Submission Form

Epping to Thornleigh Third Track Proposal. Application number SSI 5132.

Name(s): Loretta Ashton

Figure S.6 Cross-section and elevation - New Cheltenham Station concourse building (see also S.5 for artist's impression)

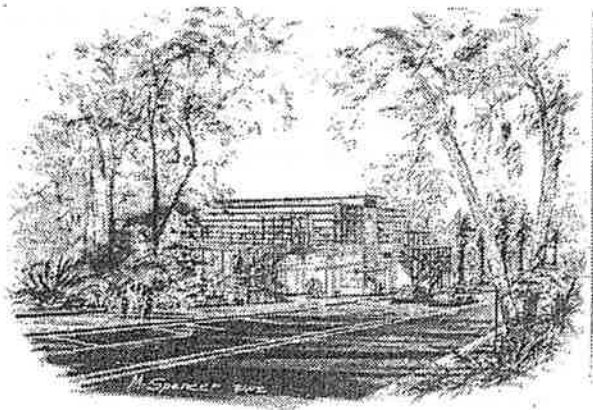
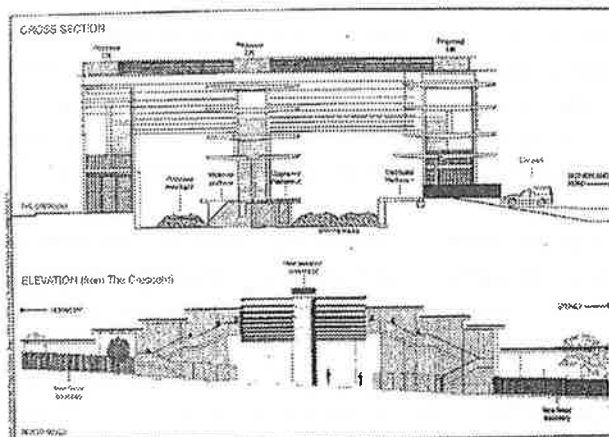
- The proposed redevelopment of Cheltenham Station shows no regard for the HCA. The visual impact of the proposed 13m high glass and steel concourse is totally unacceptable in this HCA.
